**EL PASO COUNTY PLANNING AND
 COMMUNITY DEVELOPMENT
 DEPARTMENT**

STORMWATER MANAGEMENT PLAN CHECKLIST

PCD Project Number: PPR-22-044

S9088-A-01-016

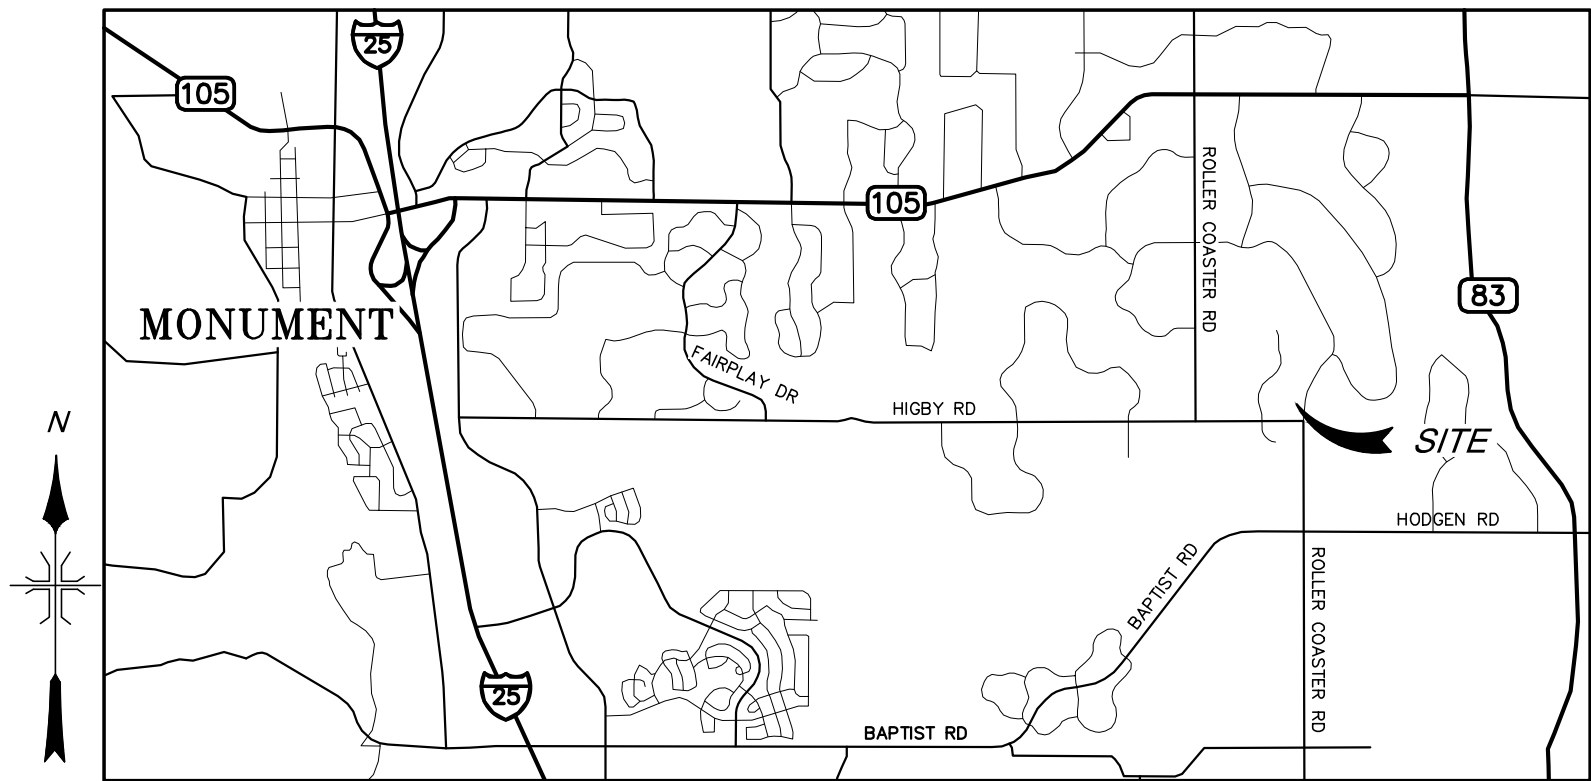
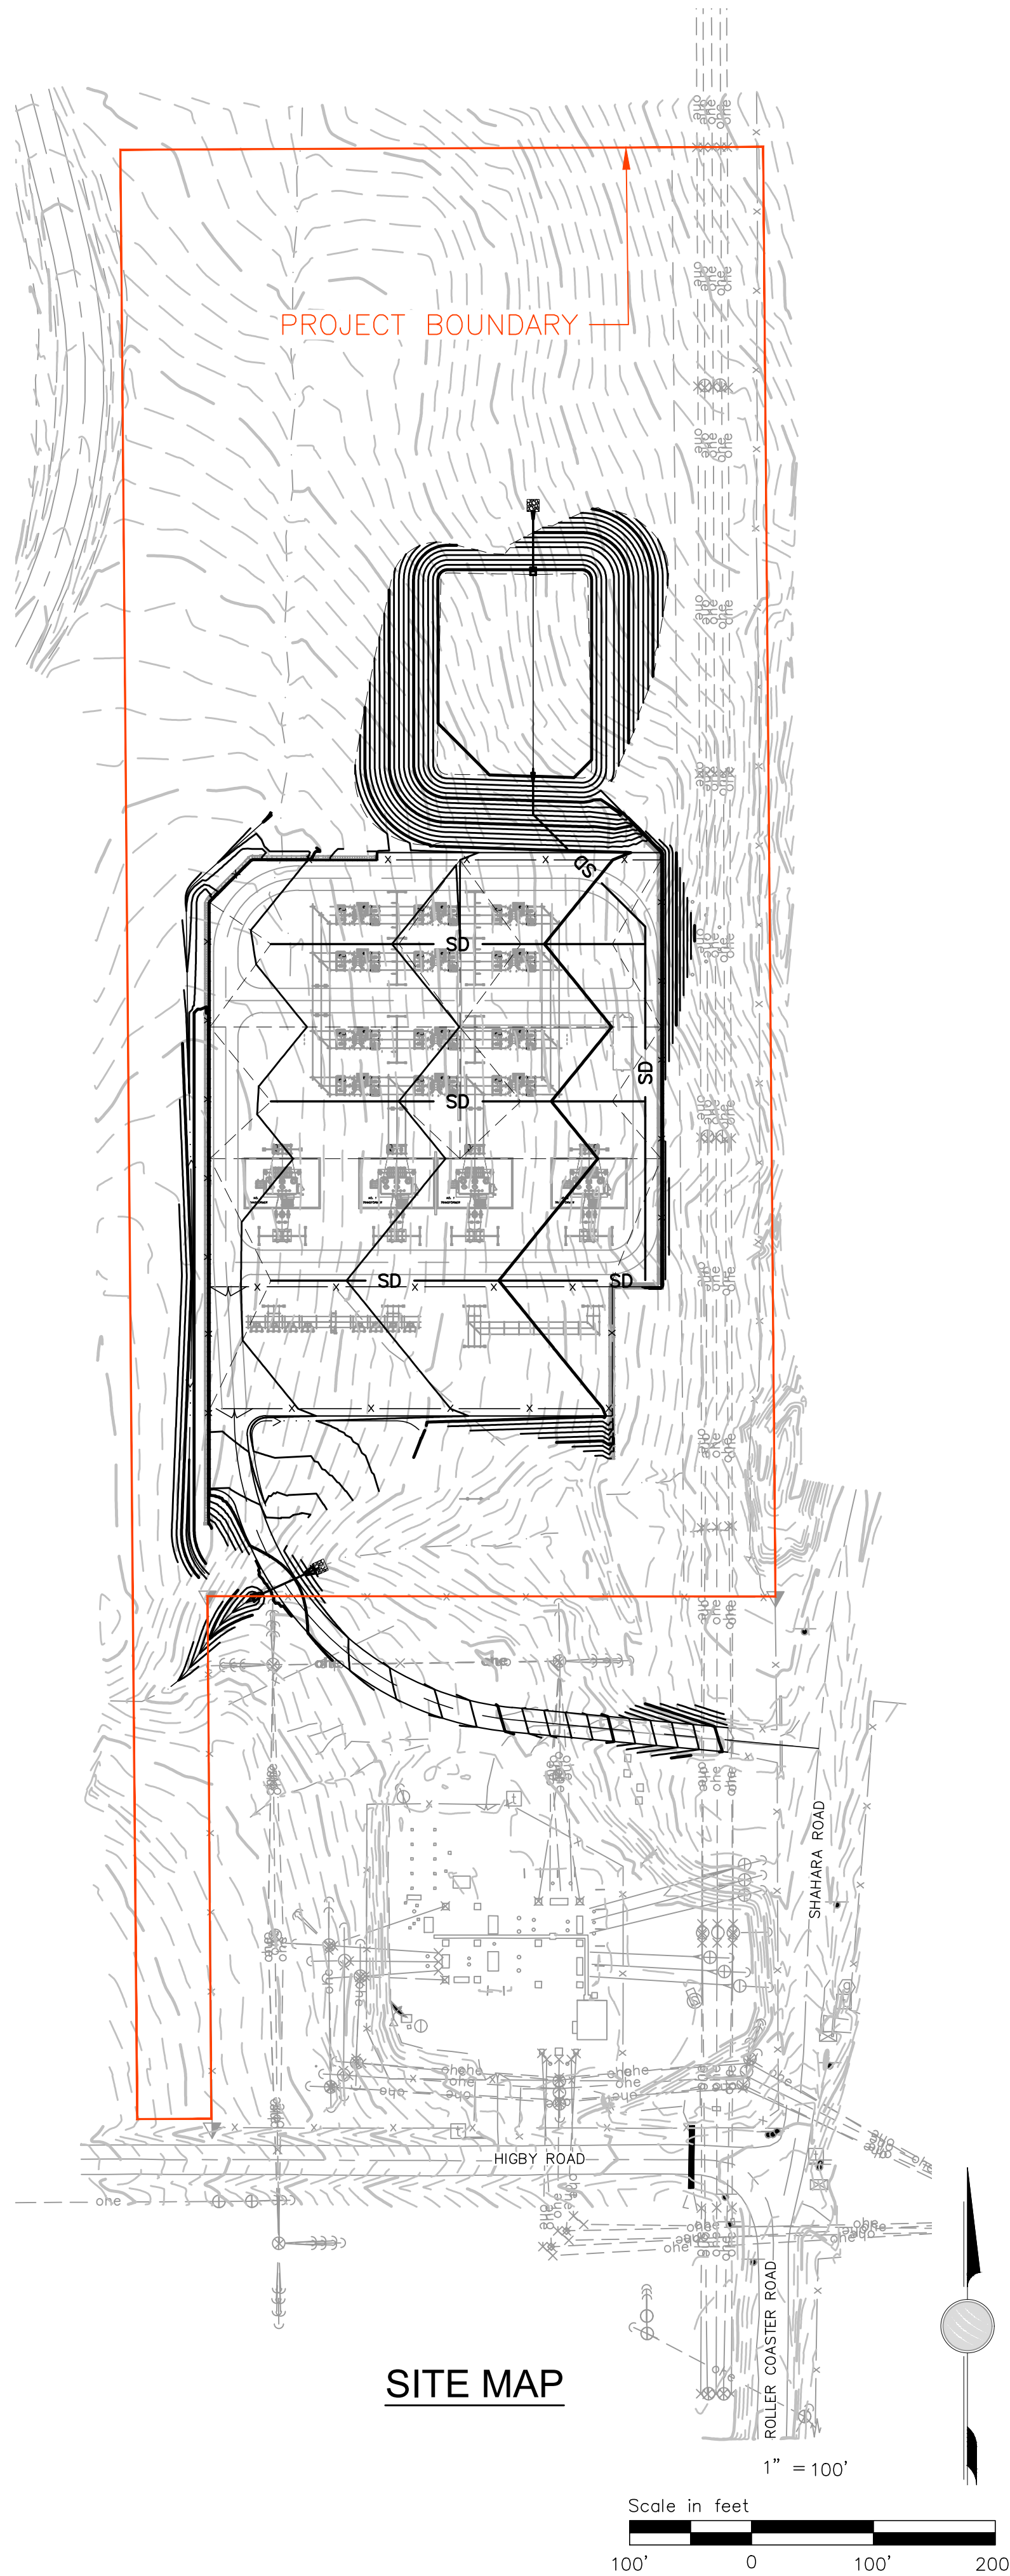
3. Applicant Comments:			
a	Update GEC plan which is used as Appendix A for this report.		
b			
c			
4. Checklist Review Certifications:
